## Appeal Decision

**Appeal Ref: APP/R5510/D/23/3329321**

**7 The Paddock, Ickenham, Hillingdon, UB10 8RB**

Client	MRS EMILY VAUGHAN.	Site	7, THE PADDOCK, ICKENHAM, HILLINGDON, UB10 8RB.
Project	GROUND FLOOR REAR AND FIRST FLOOR SIDE EXTENSIONS.	Title	EXISTING AND PROPOSED BLOCK PLANS.
Scale	1:100 @ A3	Date	13/06/2023

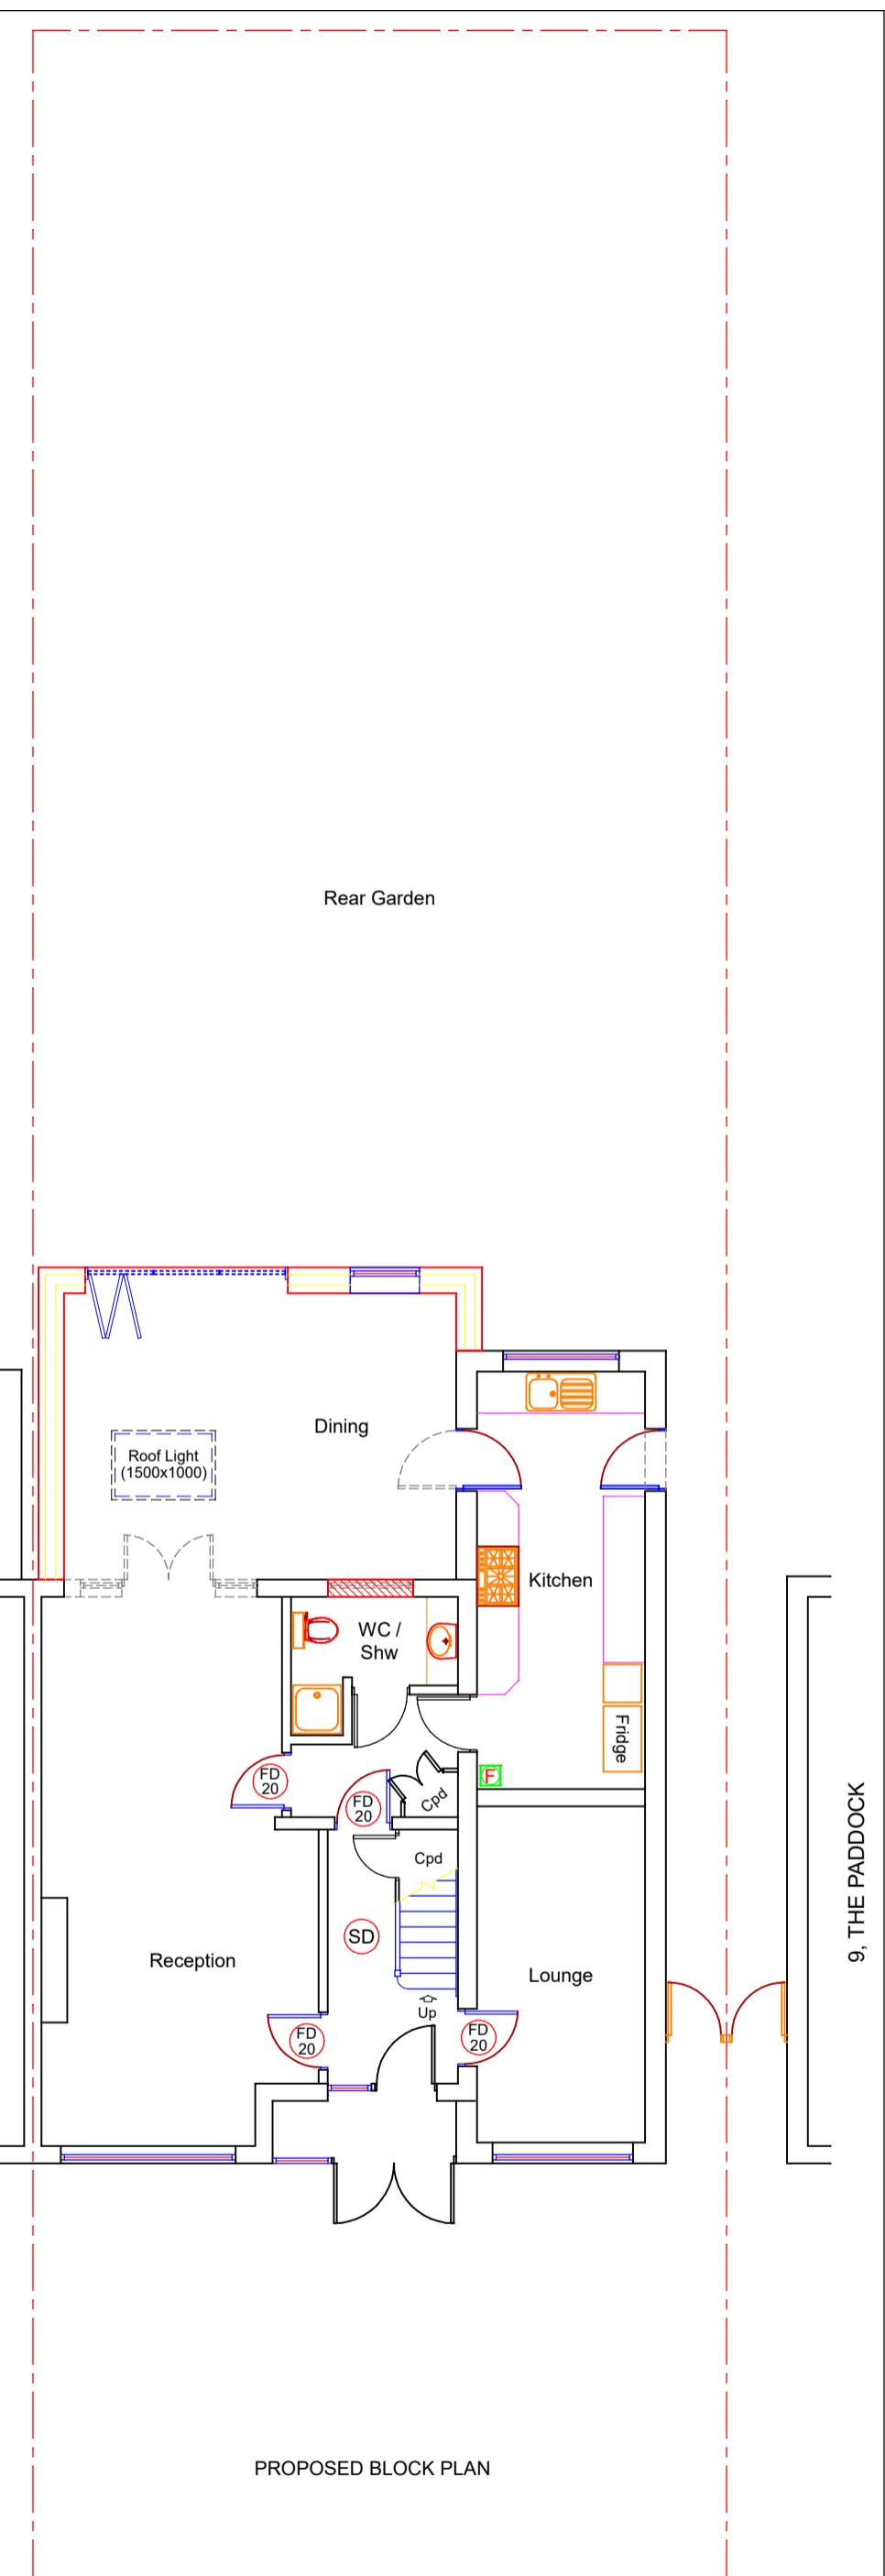
10. The proposed development would result in a first floor extension to the side, close to the shared boundary with No 9. Whilst to some degree, when seen from the front, this proposed first floor extension would reflect the two storey extension to the side of No 9, the rearward projection would, as proposed, extend well beyond the rear elevation of No 9.

11. Further, there would only be a small gap between the side elevation of the proposal and the shared boundary with No 9. I find that this very close proximity to No 9 would combine with the proposal's two-storey height and rearward projection to result in it appearing as large and unduly dominant feature when seen from the rear windows and garden of this neighbouring dwelling.

Client		MRS EMILY VAUGHAN.		Site		7, THE PADDOCK, ICKENHAM, HILLINGDON, UB10 8RB.			
Project		GROUND FLOOR REAR AND FIRST FLOOR SIDE EXTENSIONS.		Title		PROPOSED FIRST FLOOR PLAN.			
Scale		Date		Drawn by		Drg. No		Revision	
1:100 @ A3		13/06/2023		SSC		7THEPADOK/FPA/6		0

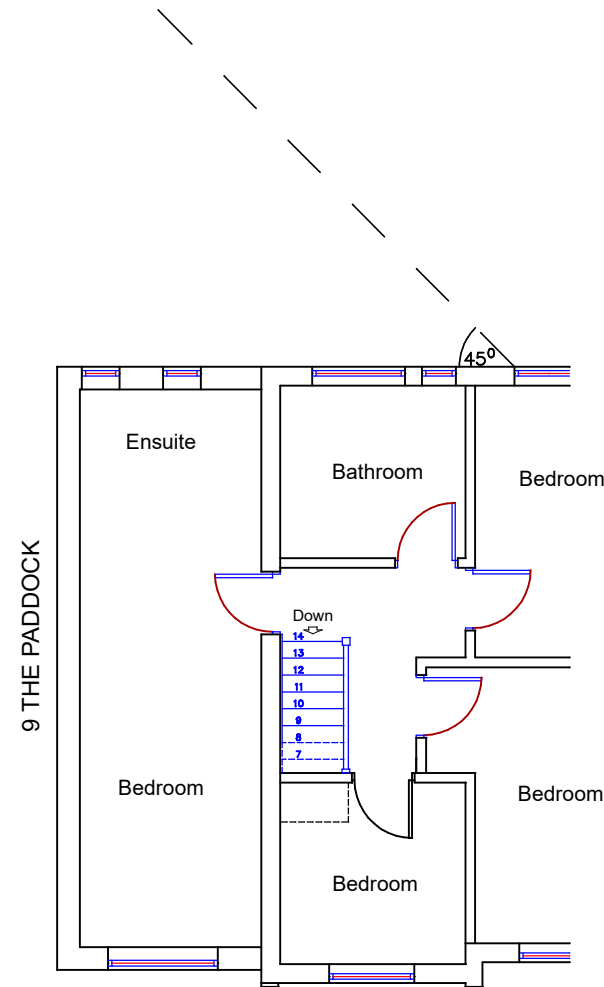
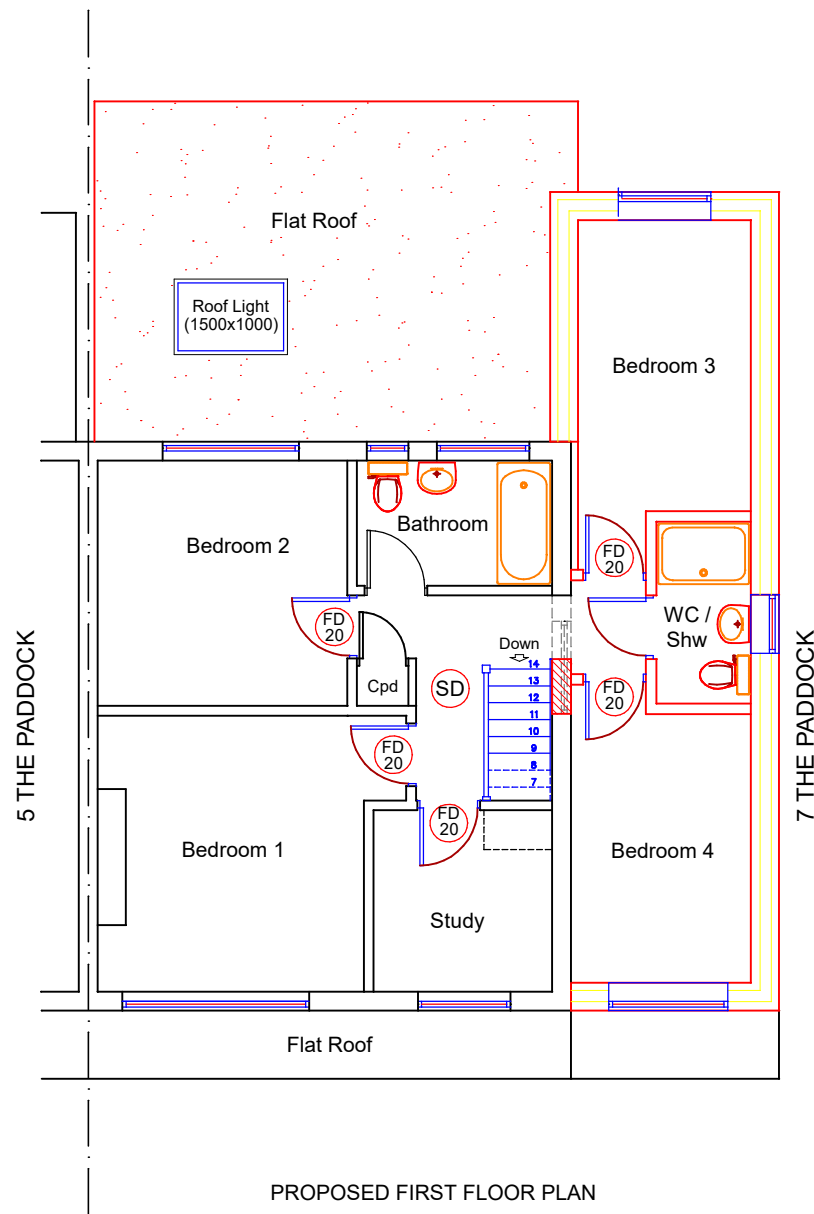
12. In this regard, I find that the proposal would draw the eye as a tall and imposing feature, such that it would appear to "loom" over that part of No 9's garden closest to the dwelling to an overbearing degree, resulting in an undue sense of enclosure.
